Appeal Decision

Appeal Ref: APP/R5510/D/22/3309453

21 Colbrook Avenue, Hayes UB3 1TG

- The appeal is made under section 78 of the Town and Country Planning Act 1990 against a refusal to grant approval required under Schedule 2, Part 1, Class A of the Town and Country Planning (General Permitted Development) (England) Order 2015 (as amended).
- The appeal is made by Mr Sadullah Alam against the decision of London Borough of Hillingdon.
- The application Ref 30330/APP/2022/2442, dated 2 August 2022, was refused by notice dated 12 September 2022.
- The development proposed is Single Storey Ground Floor Rear Extension.

PA 03

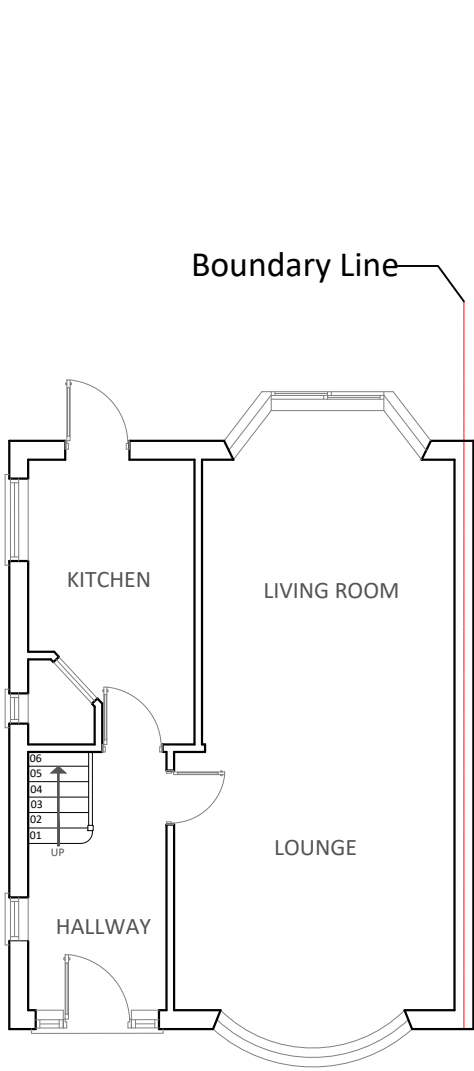
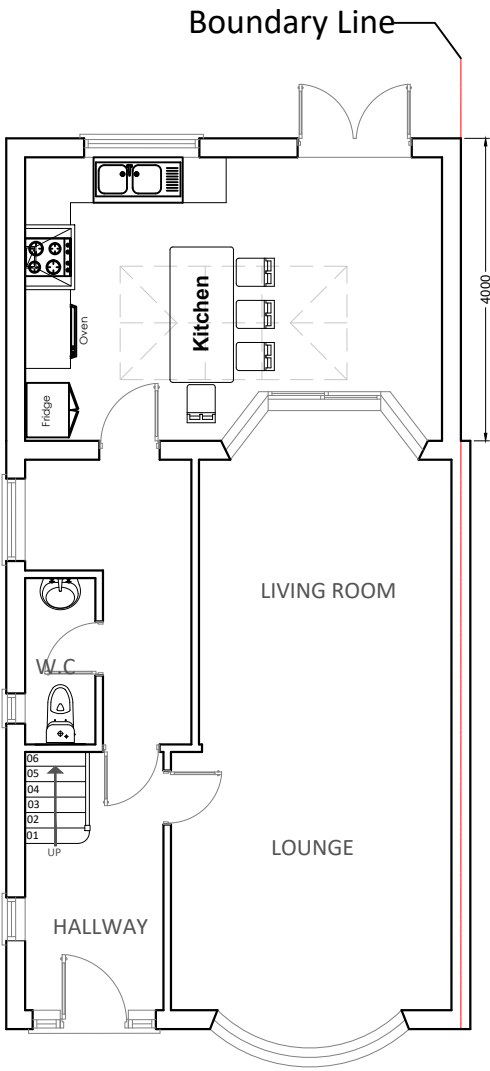
4. Paragraph A.4 requires that before beginning the development, the developer must apply to the Council for prior approval in relation to certain matters. The Council find that the proposal is not within the limitations of the GPDO and therefore refused the proposal. They consider this is because the extension would extend beyond a wall forming the side of the original dwellinghouse.

5. I could see from my inspection on site and agree with the Council that it would be reasonable to come to the view that the double height walk-in bay windows do form part of the original dwelling as this corresponds with the attached dwelling and adjacent houses. This bay extends across approximately half the

width of the dwelling with the remaining part of the dwelling flat in its appearance.

6. The chamfered edge to the bay is set in off the party boundary and has a limited projection from the back wall of the dwelling. As a matter of fact and degree, this projection does not convince me to agree with the Council's assertion that this serves to be considered as a wall forming a side elevation of the original dwellinghouse. Therefore, based on my own assessment of the facts on the ground, I am persuaded in favour of the appellant.
7. In granting approval, the Appellant should note that the GPDO requires the materials used in any exterior work to be of similar appearance to those used for the existing dwelling house. No further condition to this effect is therefore necessary.

1. The appeal is allowed and approval granted under the provisions of Schedule 2, Part 1, Paragraph A4 of The Town and Country Planning (General Permitted Development) (England) Order 2015 (as amended) (the GPDO) for a rear single storey ground floor extension at 21 Colbrook Avenue, Hayes UB3 1TG in accordance with the details submitted pursuant to Schedule 2, Part 1, Paragraph A4 (2) of the GPDO.
